February 5, 2014

**RE: Winrock Town Center Drainage Master Plan (J19/D058)  
Response to Comments**

Storm Sewer Profile

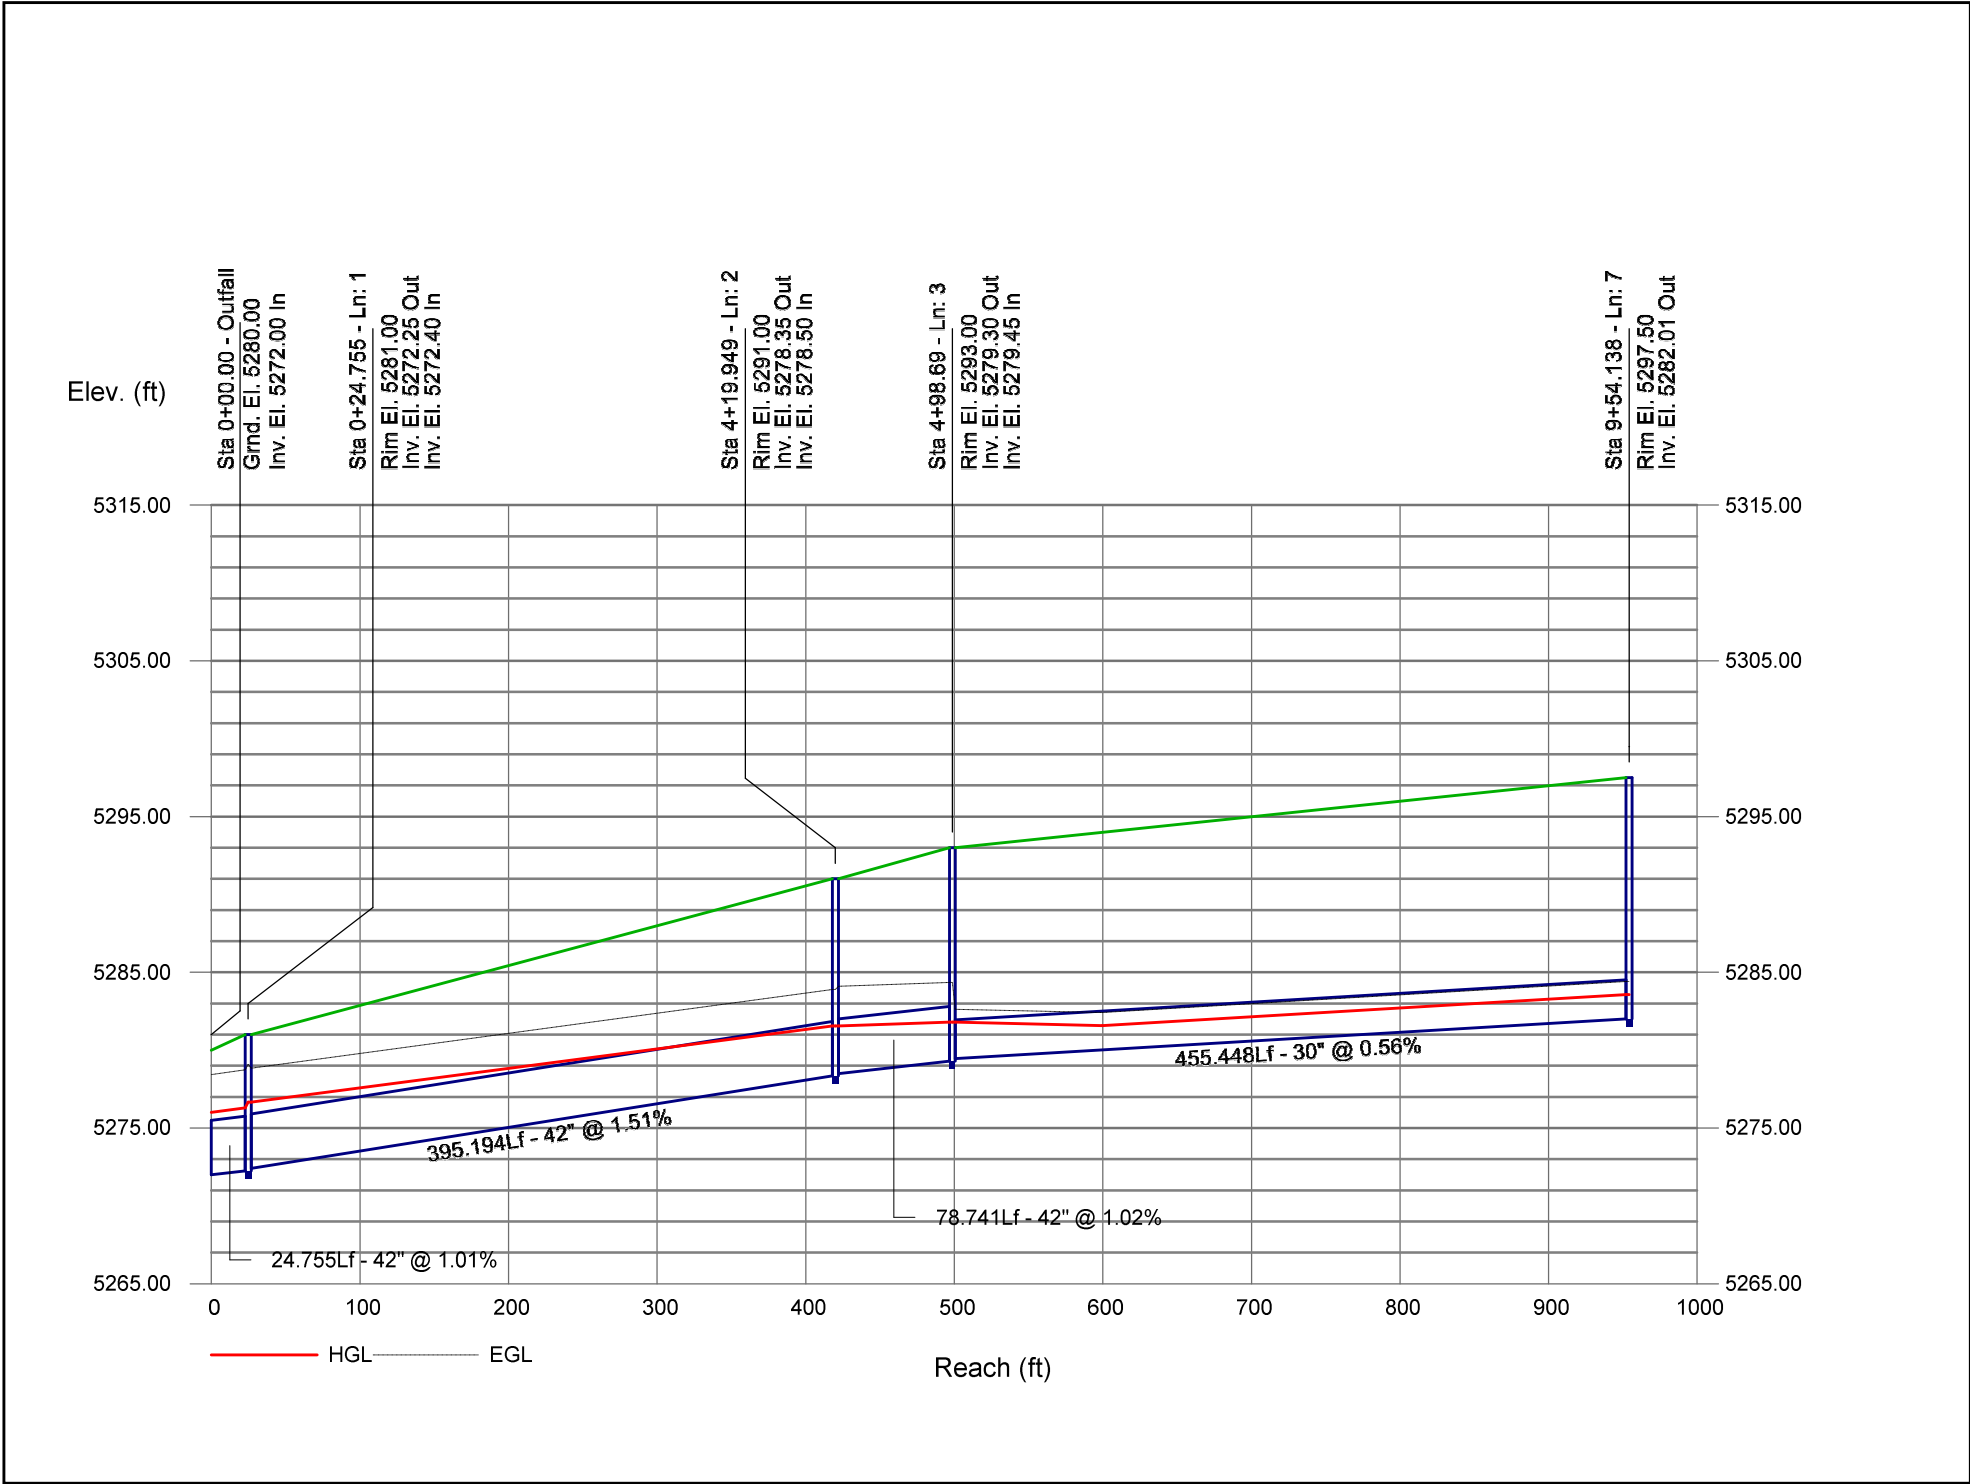
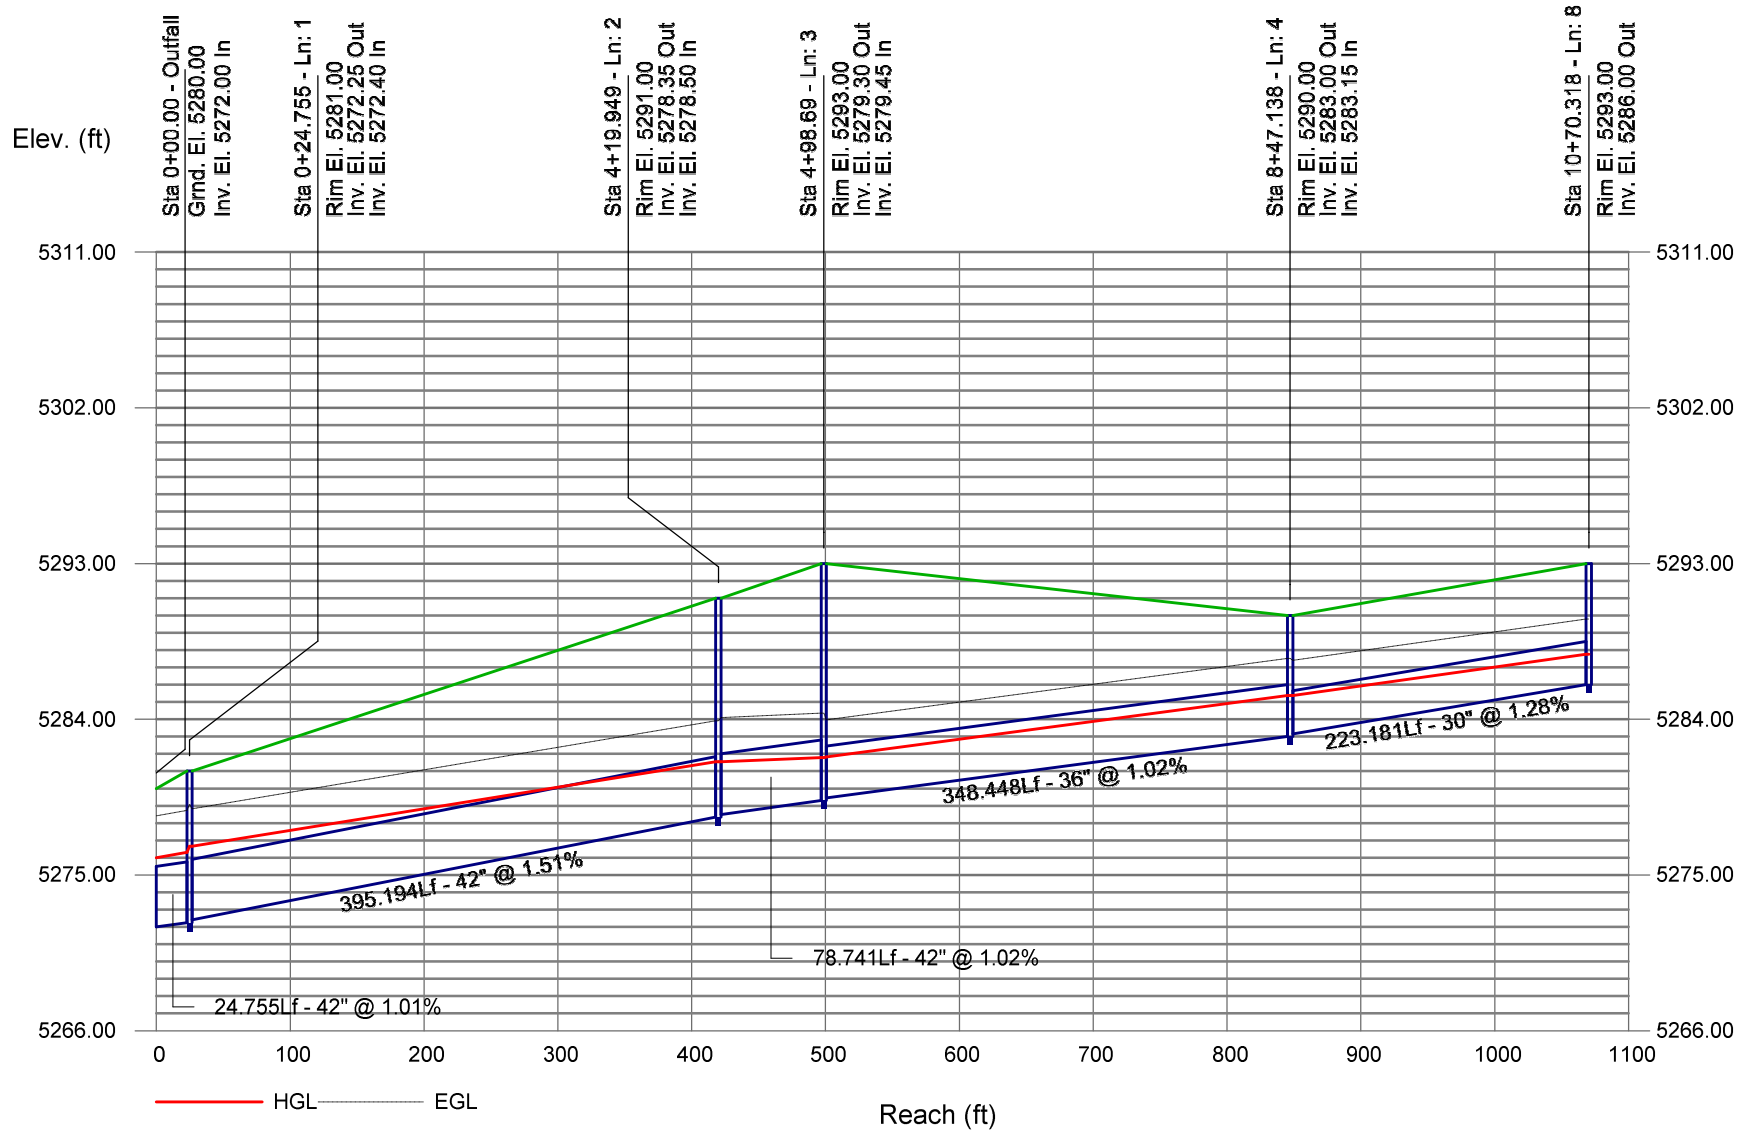
- A. For Basin 300, the flow in the Table is 120.3 cfs. The maximum flow for Basin 300 in Appendix C, Storm Drain Calculations is 81.40 cfs. Which is correct? Revise accordingly.*

The correct flow is 120.2 cfs. The discharge from the H-Z Amendment is 120.4 cfs. It is slightly lower in this revision than in the reviewed DMP because the basin lines shifted some to allow the existing storm drains to handle all of the flows. The storm drain calculations now have matching total flows.
